Application No: FG/47/22/HH
Site Address: 31 South Drive Ferring BN12 5QU
Description of works: Approval for replacement of roof void window to sliding doors.

Thank you for your internet representation made on 28th March 2022 which has been recorded as an objection with the comments as follows:

PROP. SOUTH ELEVATION 1:100

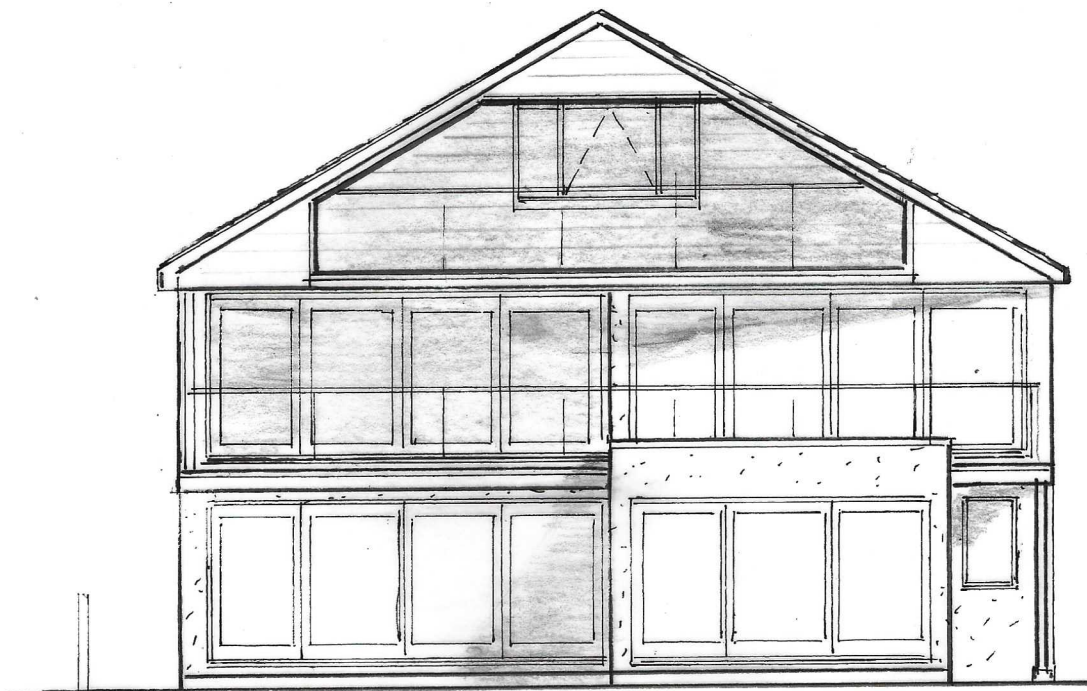
I object to the construction of the clear glass patio doors leading onto the clear glass balcony at high level which has resulted in the overlooking of our private garden and a severe loss of privacy to our kitchen diner and lounge.
